Our Ref: PM/5646

25th March 2024

RE: RECONSTRUCTED OUTBUILDING, OLD TONG FARM, TONG ROAD, BRENCHLEY

SCALE 1:50@A1 -- EXISTING EAST ELEVATION FRAMING
(shown as if still intact, level and plumb)
Frame viewed from outside

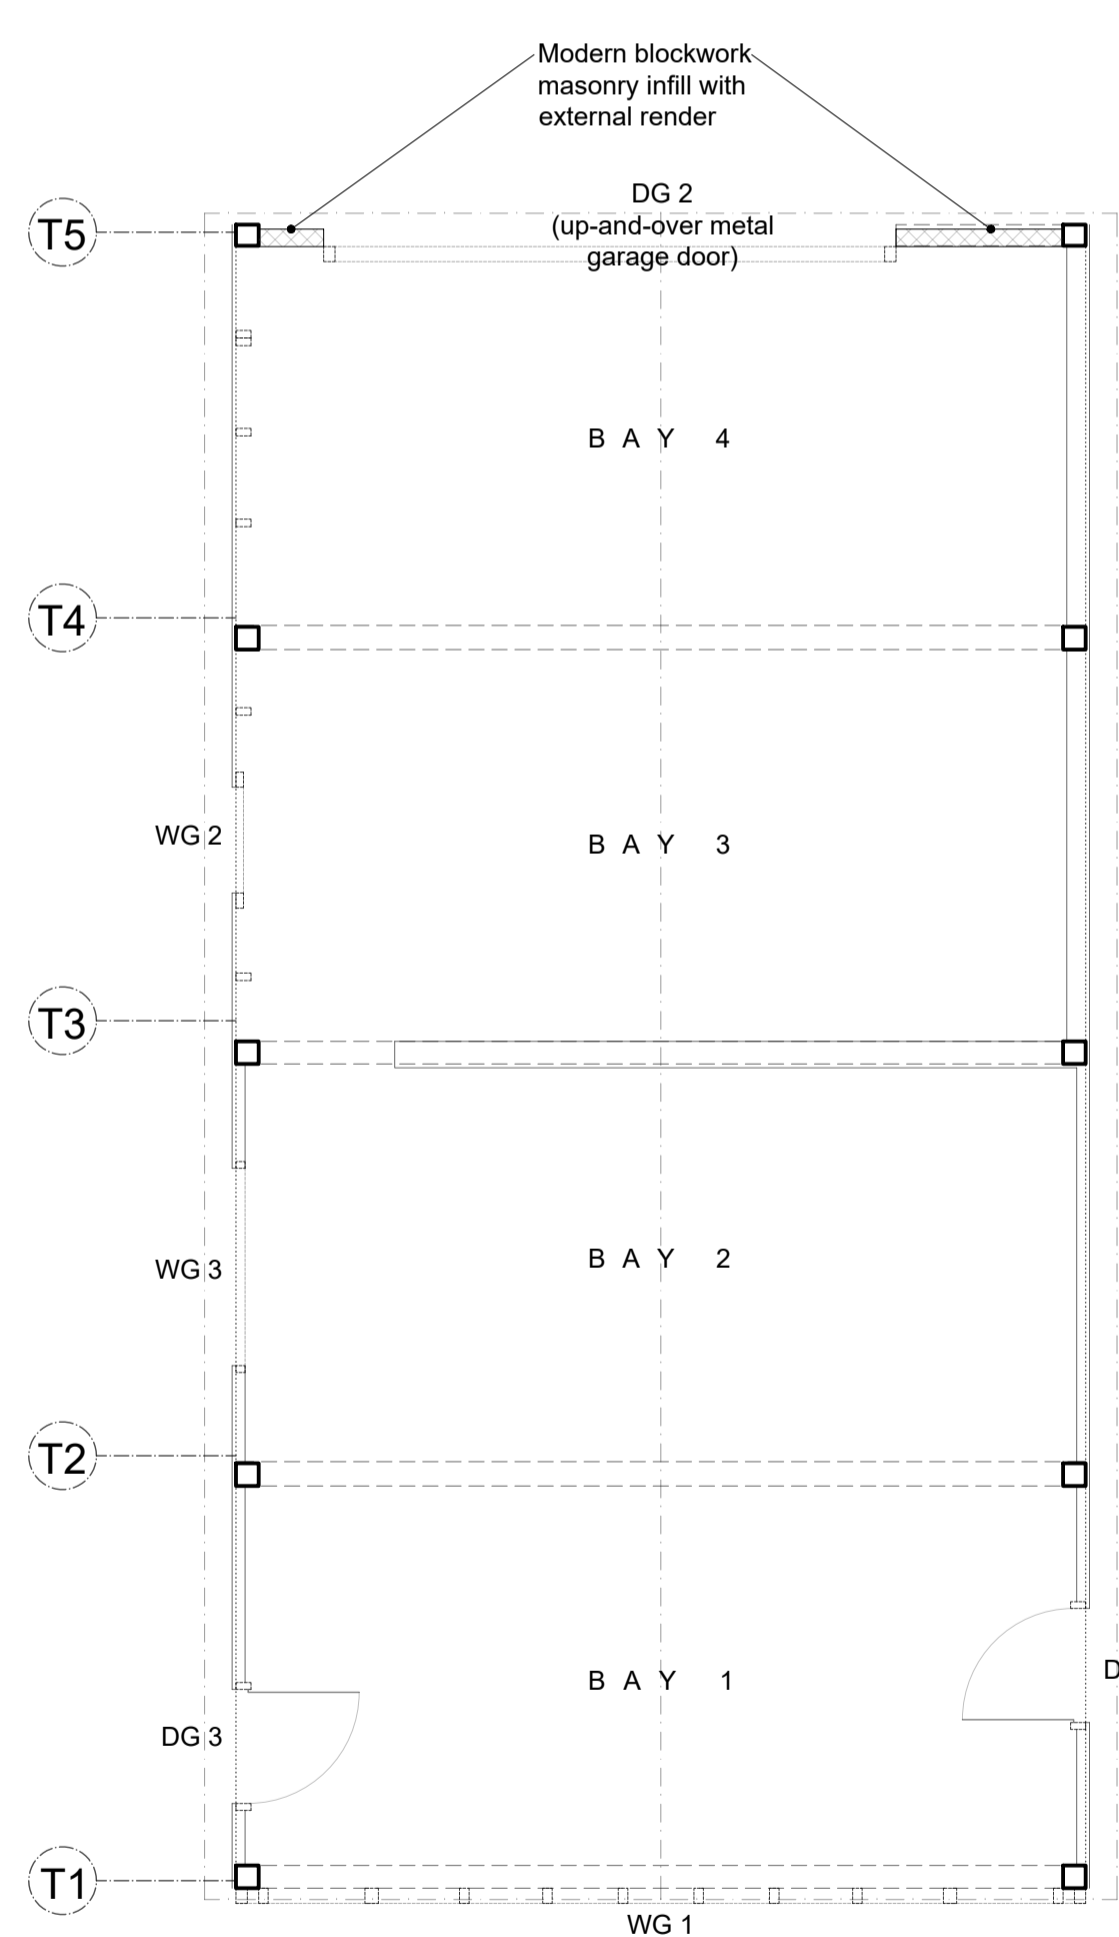
As noted in Anthony Hicks method statement, the barn has severely racked towards the east (see plate 3) and is currently reliant on an adjacent outbuilding to prevent collapse. Our preliminary calculations suggests that the existing posts and knee braces are well undersized with calculated deflections in the excess of 50mm.

As a result, we feel that the posts and knee braces require replacement with more substantial sizes. These have been calculated as 200mm x 175mm posts that are jowelled to 200mm square above the level of the knee brace. The knee braces should be a minimum of 70x120mm and should be connected to the post and tie beams with mortise and tenon joints with 2No. stainless dowels per tenon. The knee braces will also need to be lower to ensure they are effective (900mm below the tie beam).

SCALE 1:50@A1 -- EXISTING TRUSS 4 FACING SOUTH
(shown as if still intact, level and plumb)
Frame viewed from outside

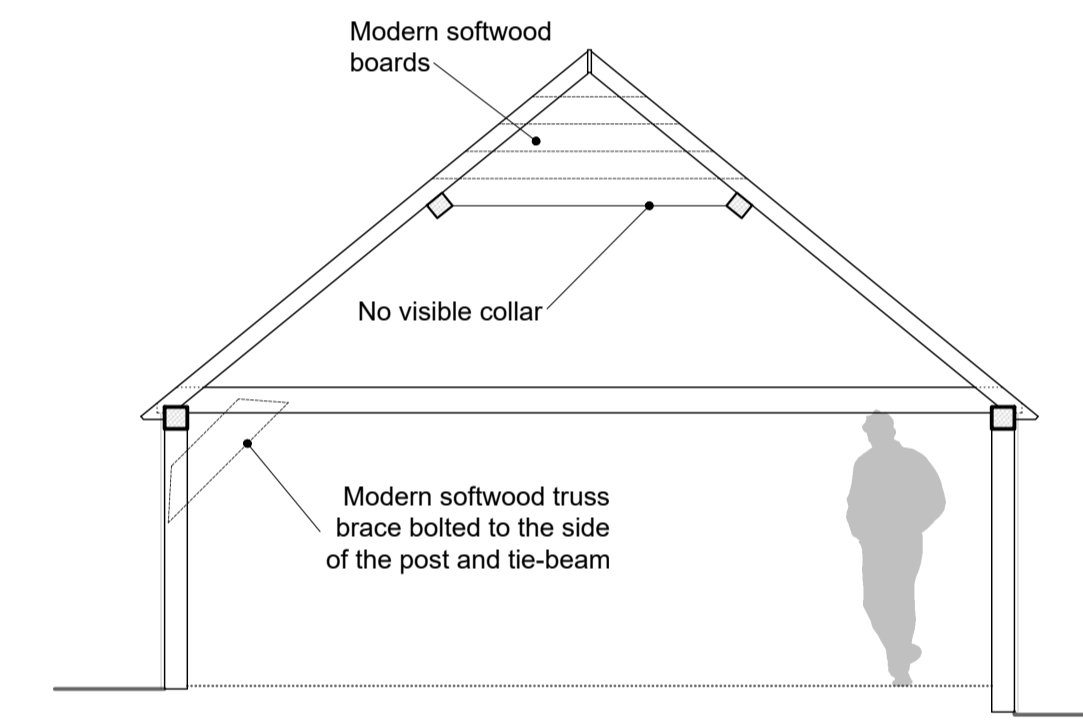
Our preliminary calculations indicate that the existing rafters, purlins, collars, eaves plates and the internal tie beams are all adequate so we are of the opinion that all of these elements can be retained. The lack of collar on truss 4 can be rectified by installing a

replacement horizontal collar or by two vertical posts onto the tie beam below. Minor movement was noted to the connections between the tie beams and eaves plate and the existing straps are minimal, so we would recommend that these joints are supplemented with more substantial traditional steel twisted blacksmiths straps (60x10mm thick x min 750mm long).

SCALE 1:50@A1 -- EXISTING SOUTH ELEVATION GABLE
END FRAMING - T1 (shown as if still intact, level and plumb)
Frame viewed from outside

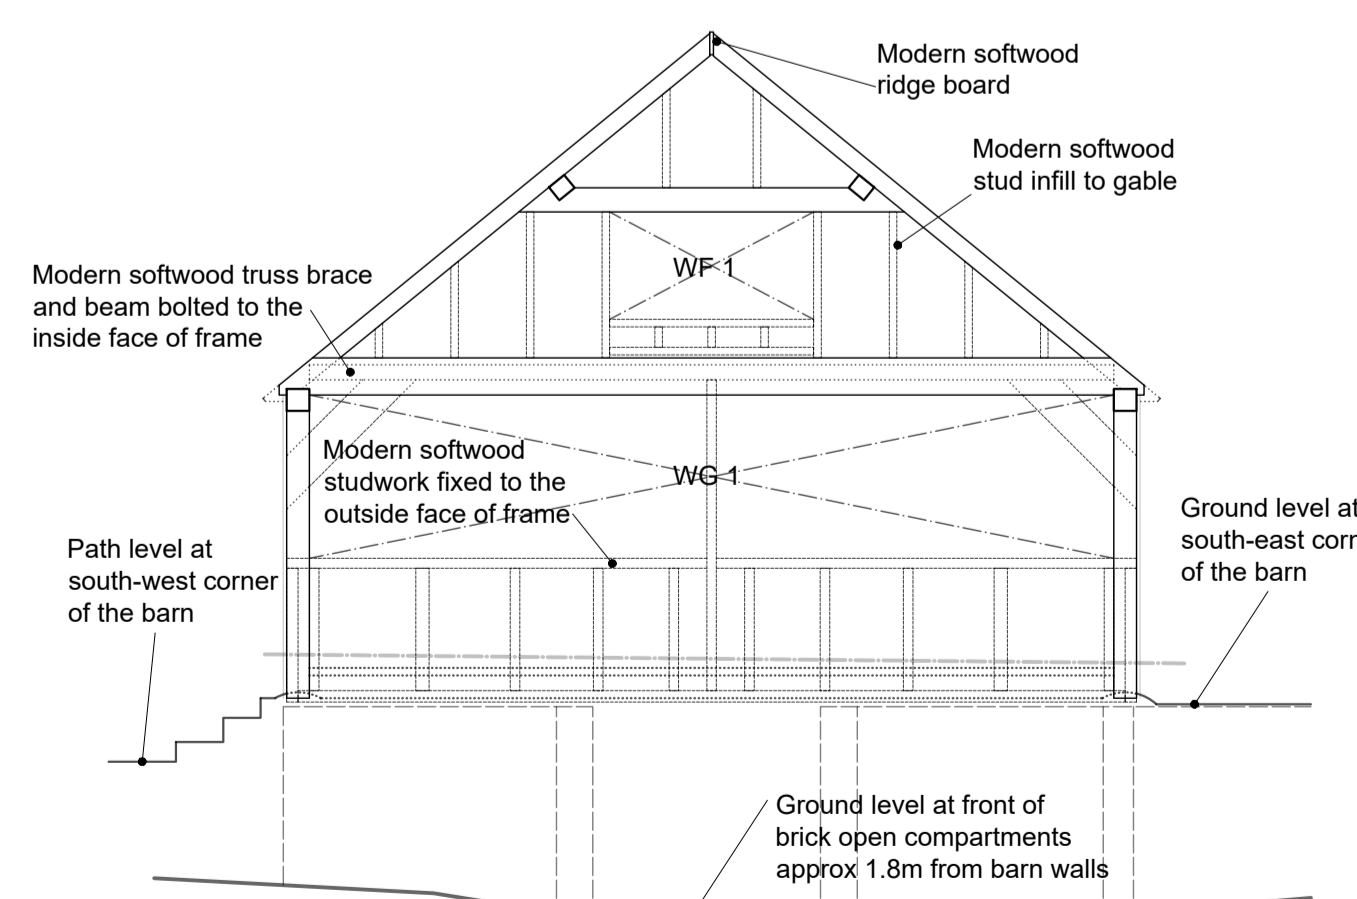
The tie beam to the south elevation external wall is decayed and fractured, so will need replacing in its entirety with an oak beam with size to match the existing. The tie beam to the north elevation is only present for a very short length and appears to have been cut out to allow for the up and over garage doors. This will need to be rectified by splicing in a new oak tie beam to the existing sections.
